CITY OF ALBUQUERQUE

December 14, 2021

RE: Juan Tabo Hills Estates
LOMR Request Engineer's Stamp Date: 08/02/2021
Hydrology File: M21D018

PROJECT Twin Turbo Hills West
SUBJECT Section 3
BY _____ DATE _____
CHECKED _____ DATE _____
SHEET _____ OF _____

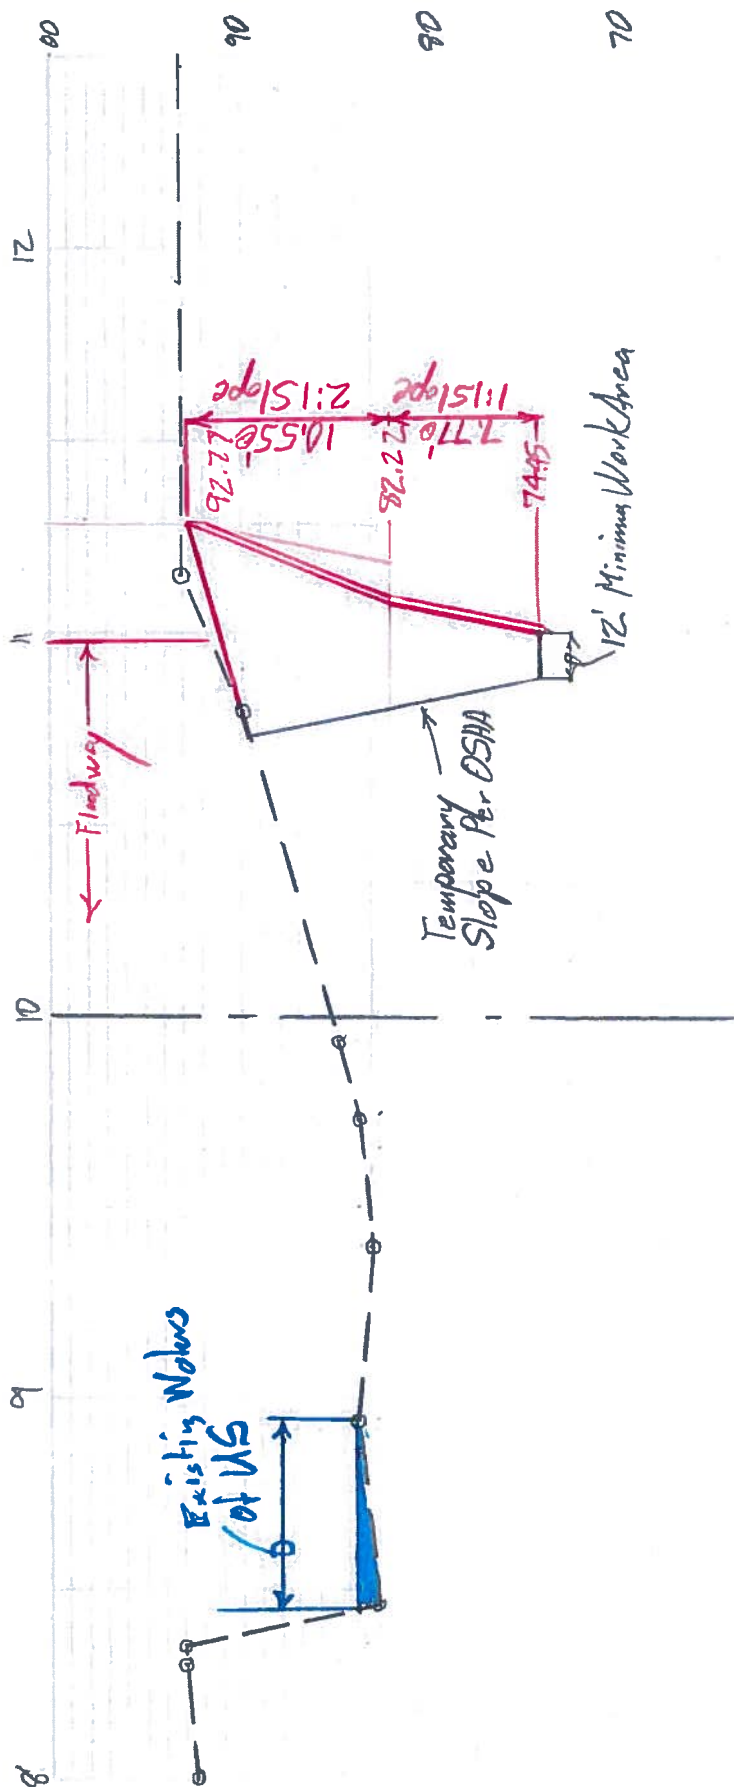
question the upstream Sections (20 – 70). How accurate are those sections. I would highly recommend that Sections 2.9 – 15 be surveyed and use these survey points for the model.

As an example, here is Section 3 model, as-built drawing, and site visit photos.
